RE: North Andalusia – Project#1003275; Site Development Plan for Building Permit, 16EPC-40088

The purpose of this letter is to transmit the Burger King @ Heritage Marketplace for DRB review and sign-off for the Site Development Plan for Building Permit. The project was approved by the Environmental Planning Commission (EPC) on February 9, 2017. The project was appealed and upheld by the City Council on

Conditions 16EPC-4088 Site Development Plan for Building Permit

PROJECT #: 05-057  
 ROC-40 20/20  
**BURGER KING RESTAURANT**  
 LADERA AND MARKET  
 ALBUQUERQUE, NM

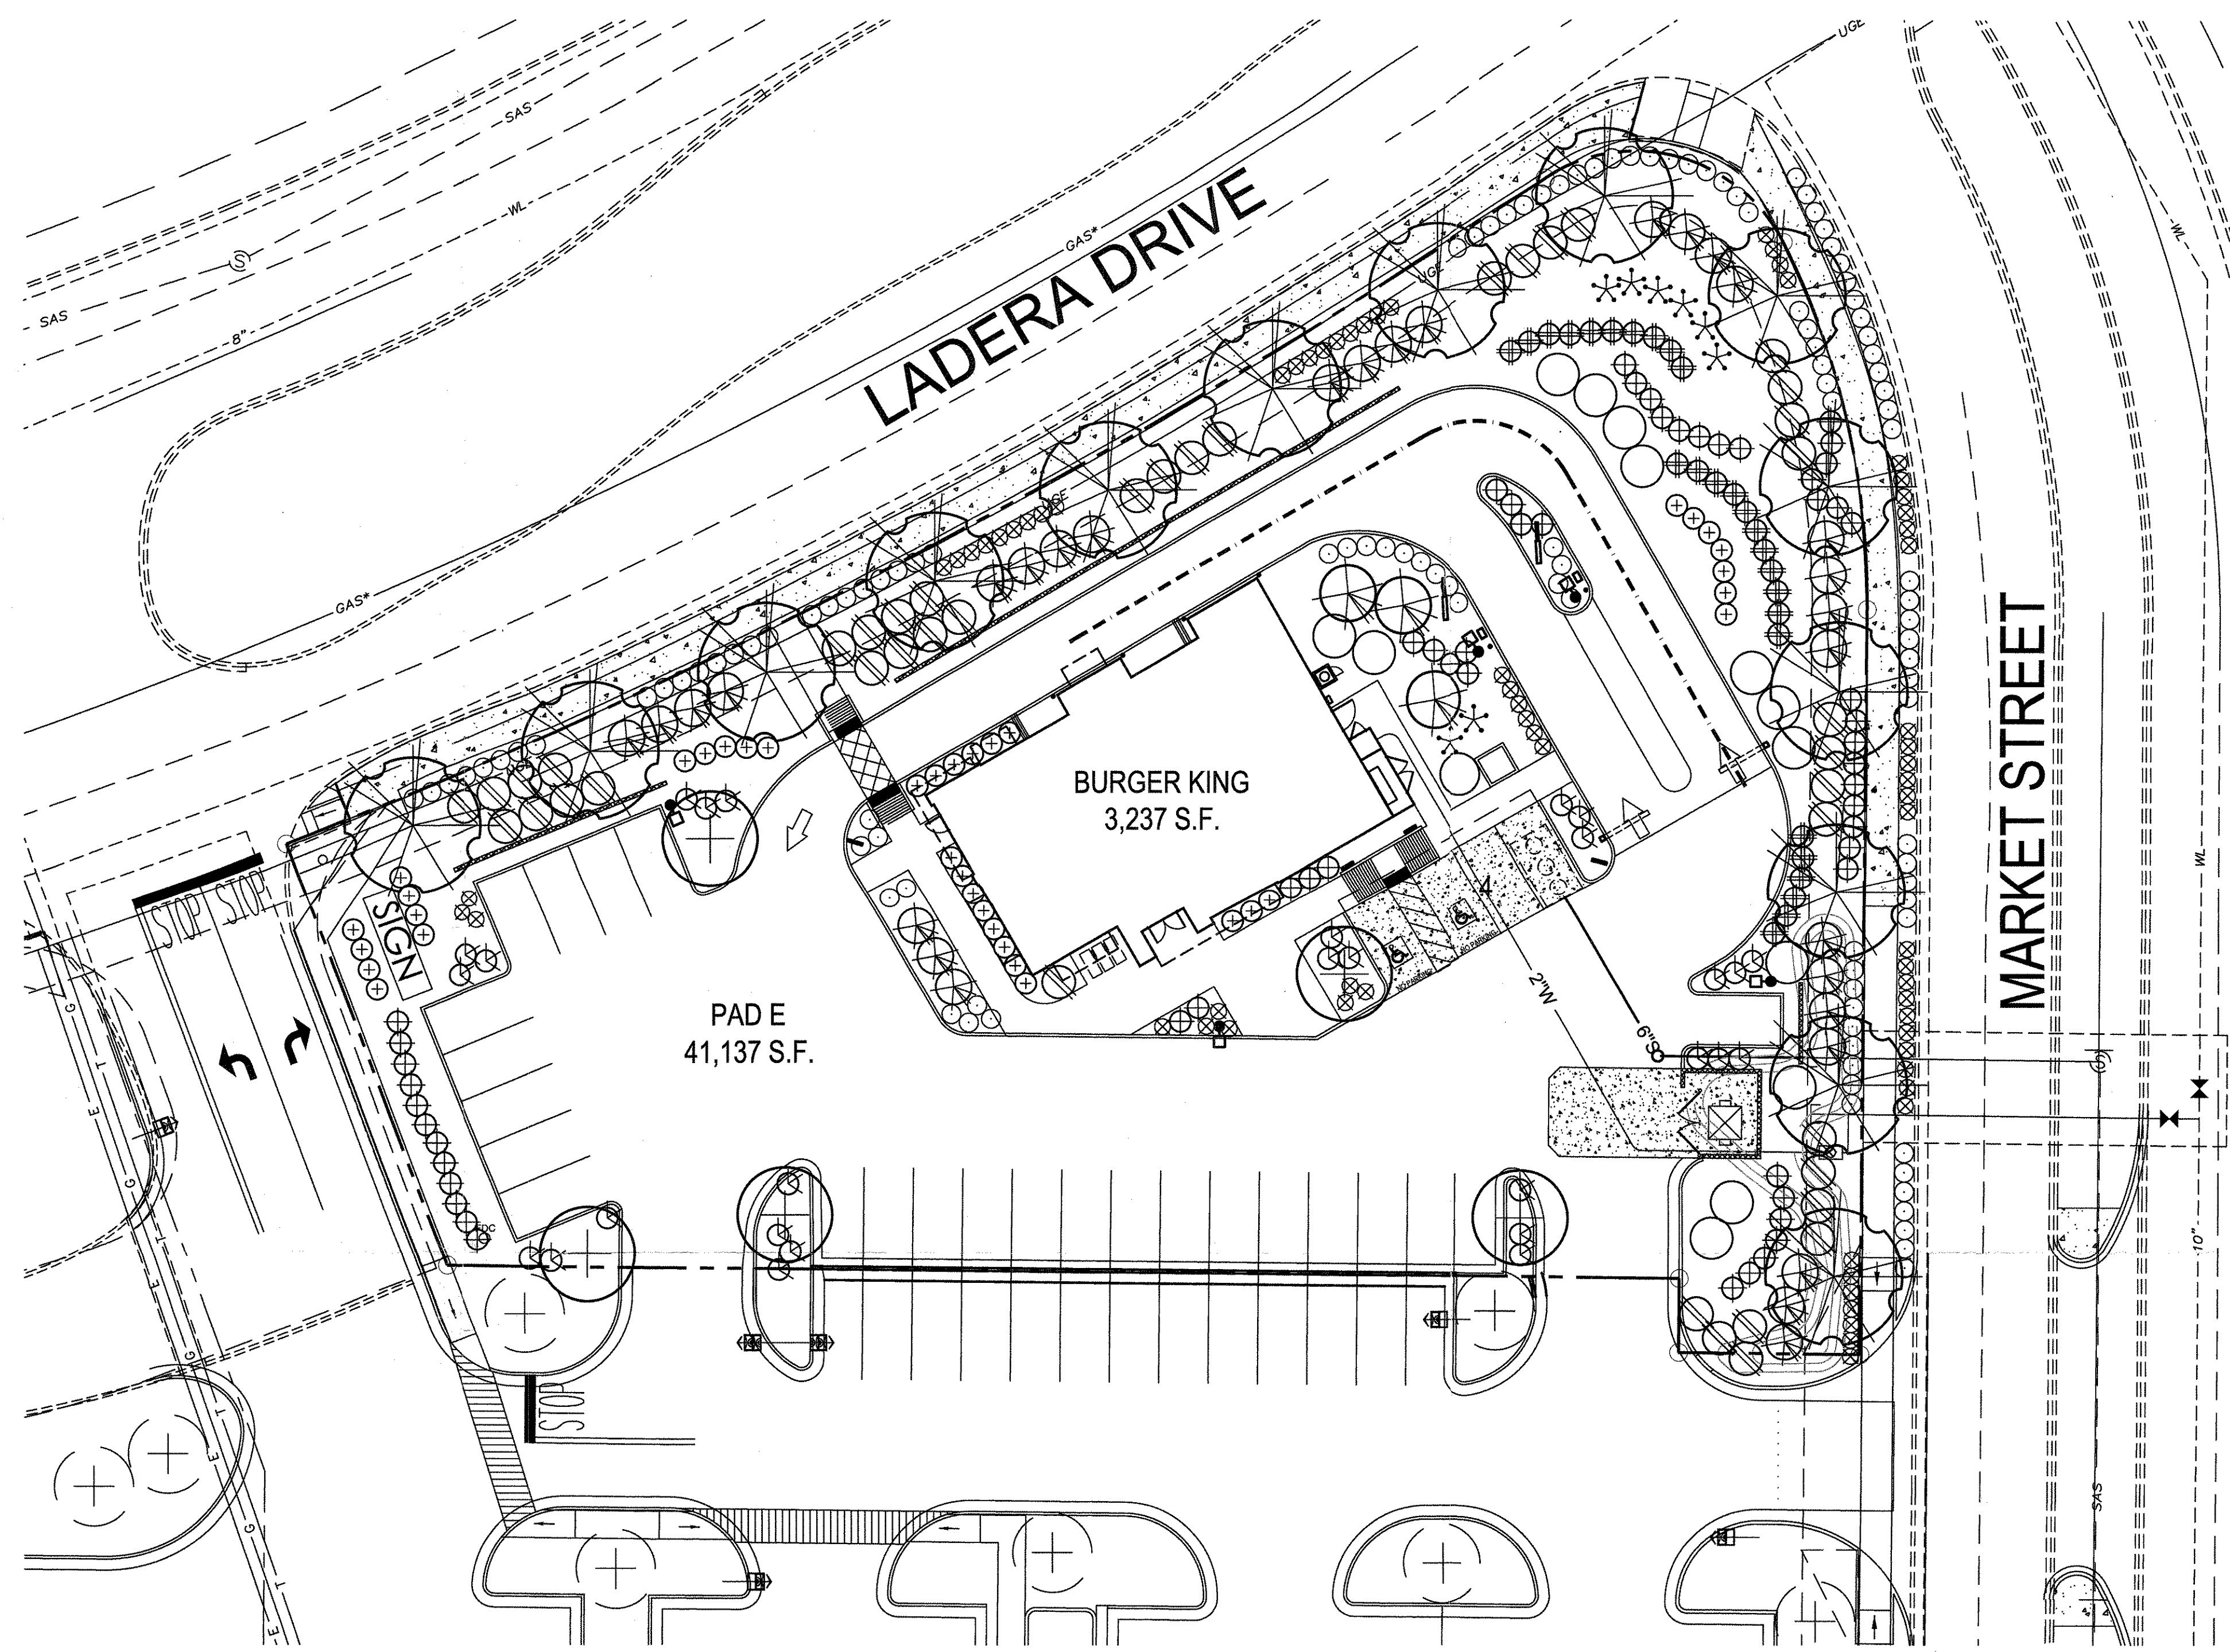
5. *Reduce screen wall height to 36 inches to comply with the approved Site Development Plan for Subdivision.*

The height of the screen wall, as noted on the Site Plan, has been reduced to 36 inches.
